CITY OF PORTLAND BUILDING PERMIT

548 ST JOHN ST

PERMIT ID: 2017-00173

has permission to **Interior renovations of all four apartments and replace all existing entry porches.
Demo permit was submitted separately.**

BASEMENT AND FIRST
FLOOR REMOVALS PLAN

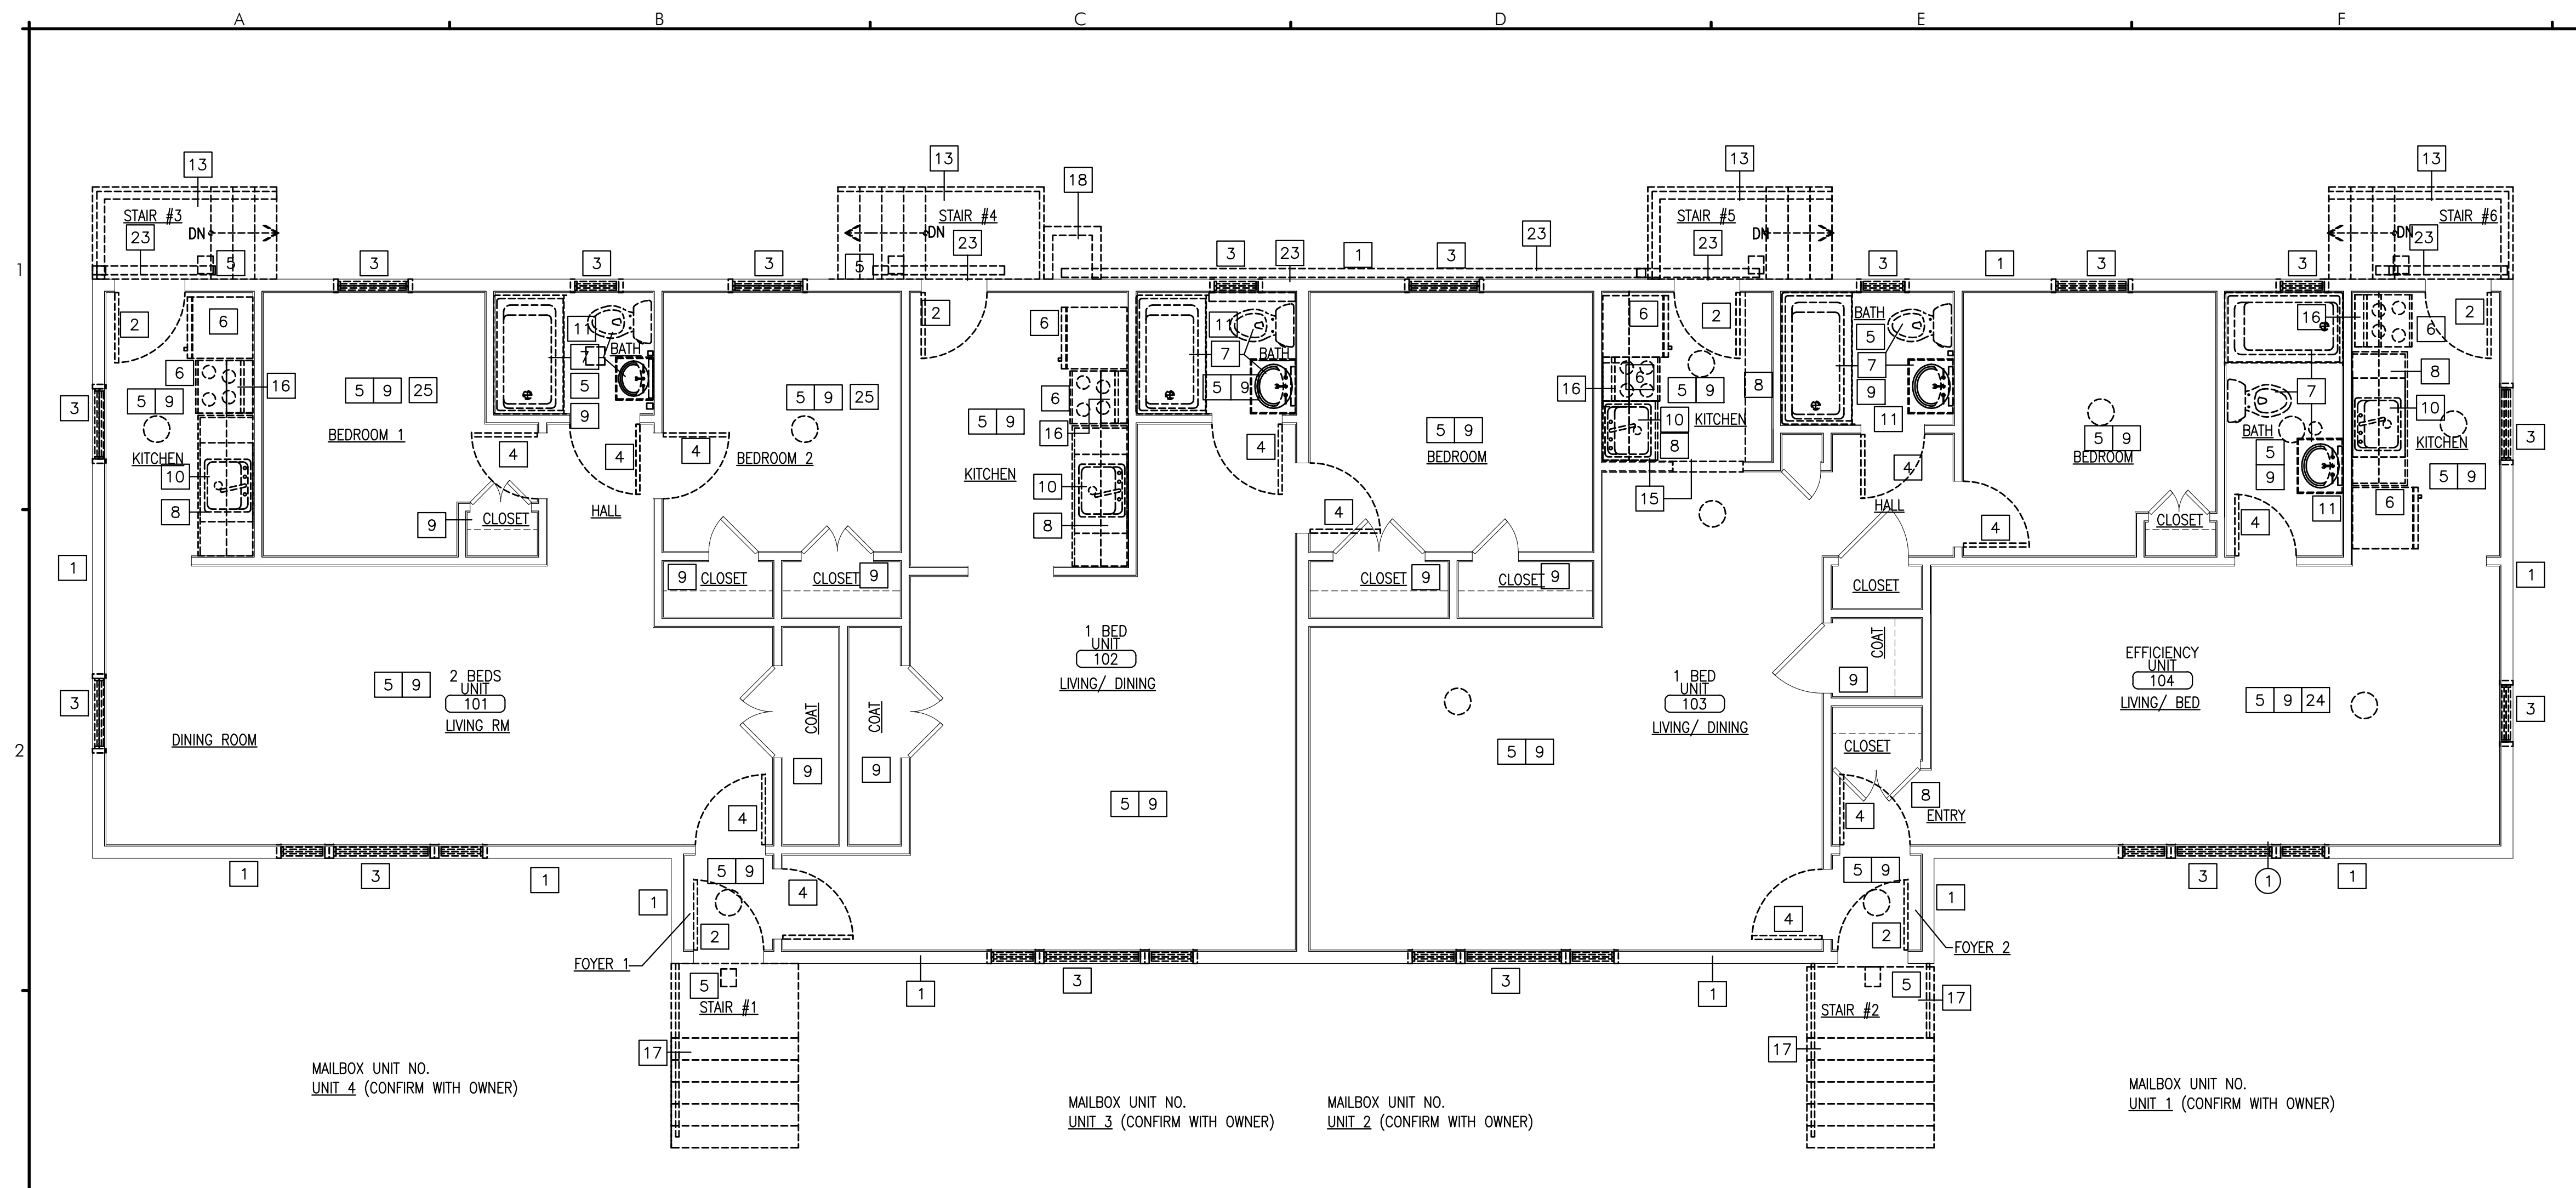
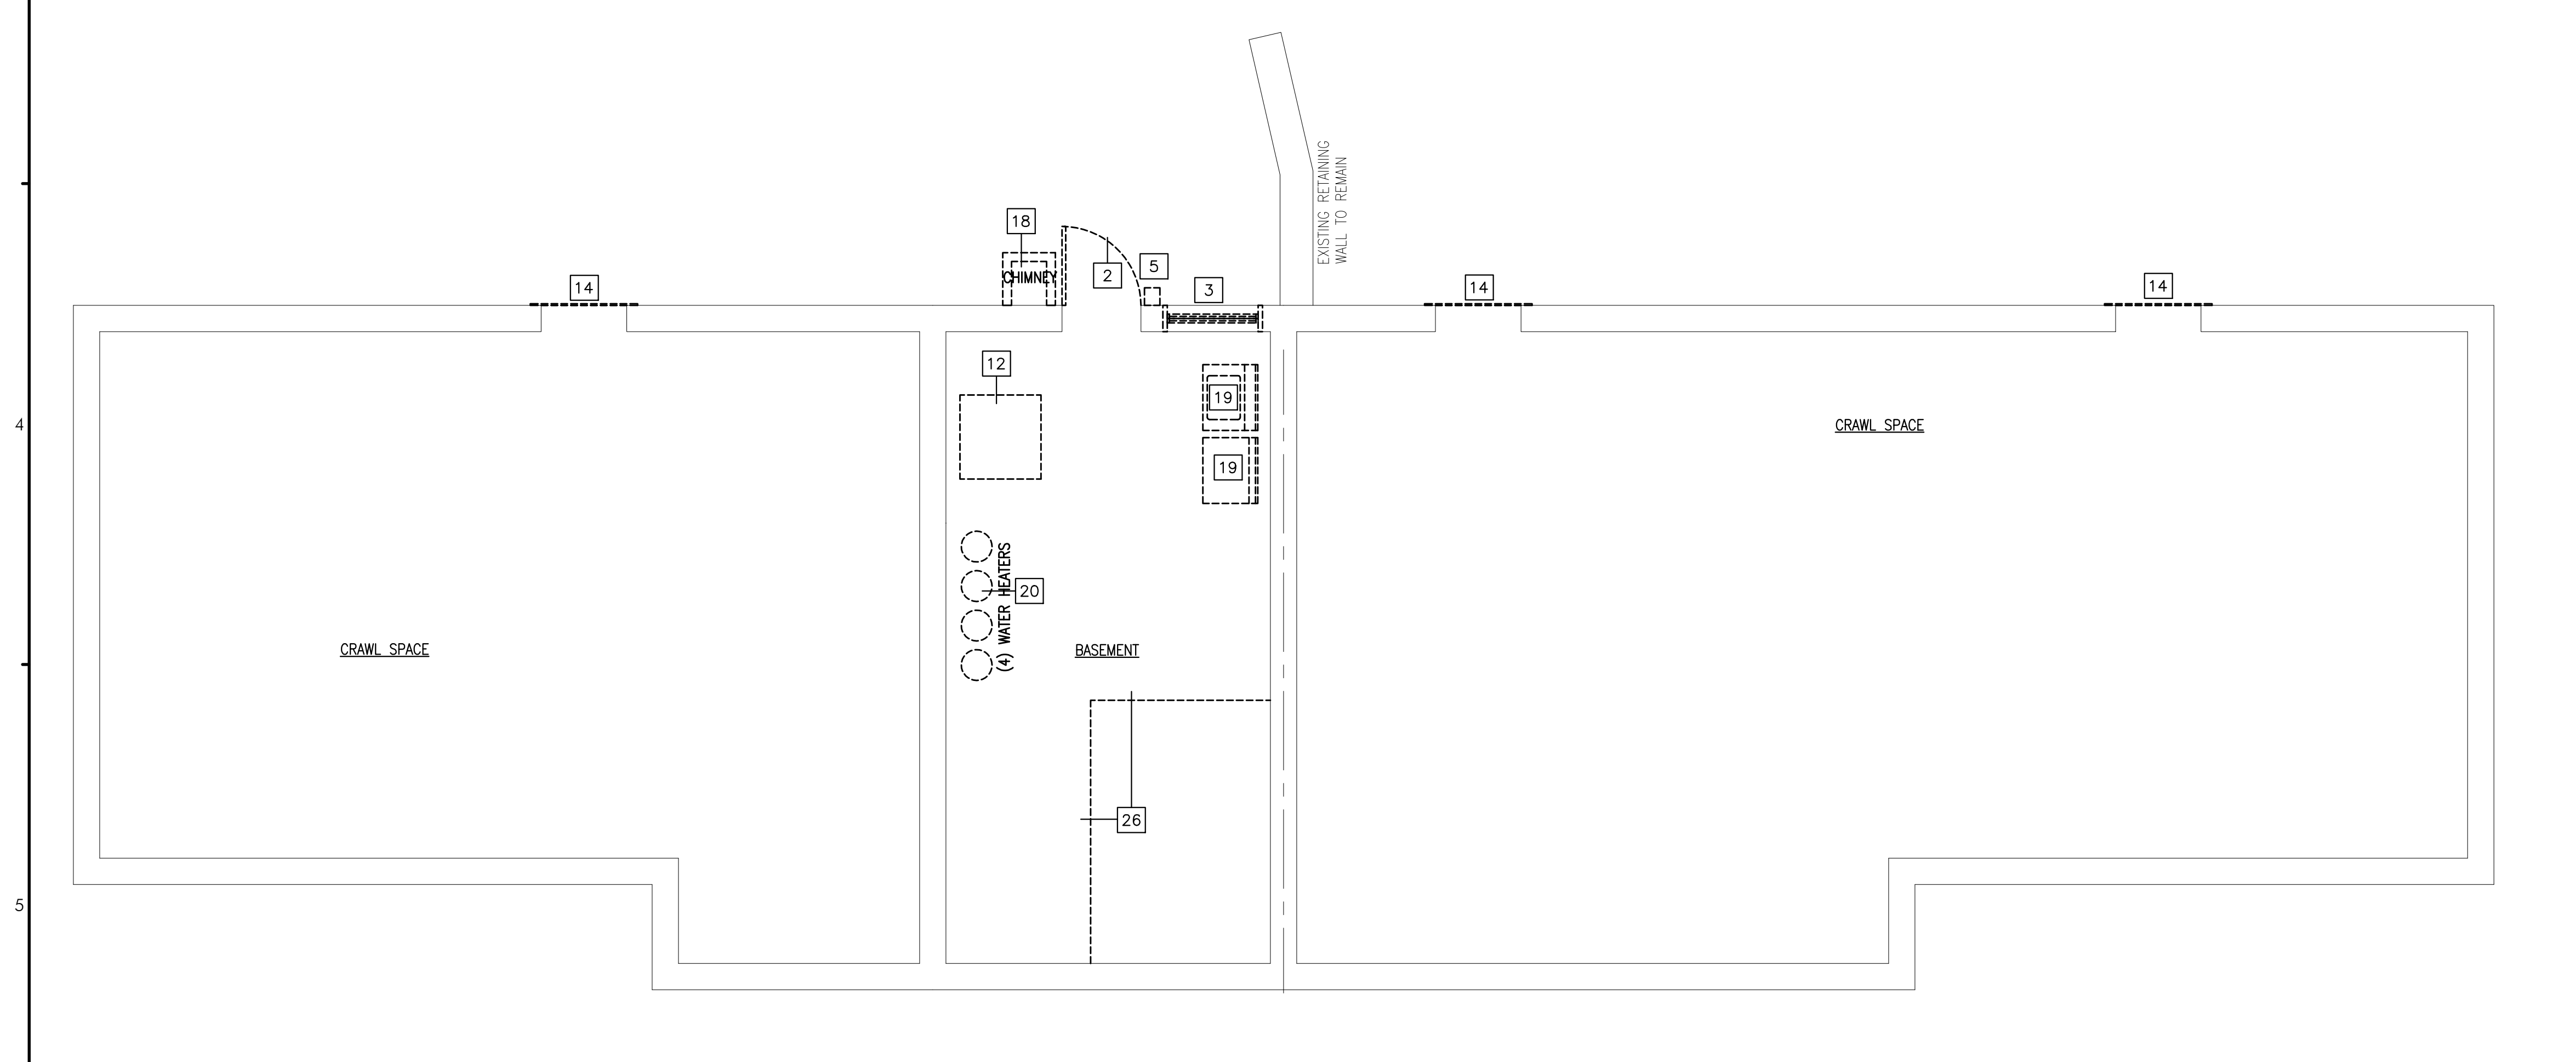
Dept: Fire Status: Approved w/Conditions Reviewer: Jason Grant Approval Date: 05/04/2017 Note: Ok to Issue: <input checked="" type="checkbox"/> Conditions: 1) Any penetrations in the basement laundry / furnace room area walls or ceiling shall be protected and sealed by a listed firestop system and or device.
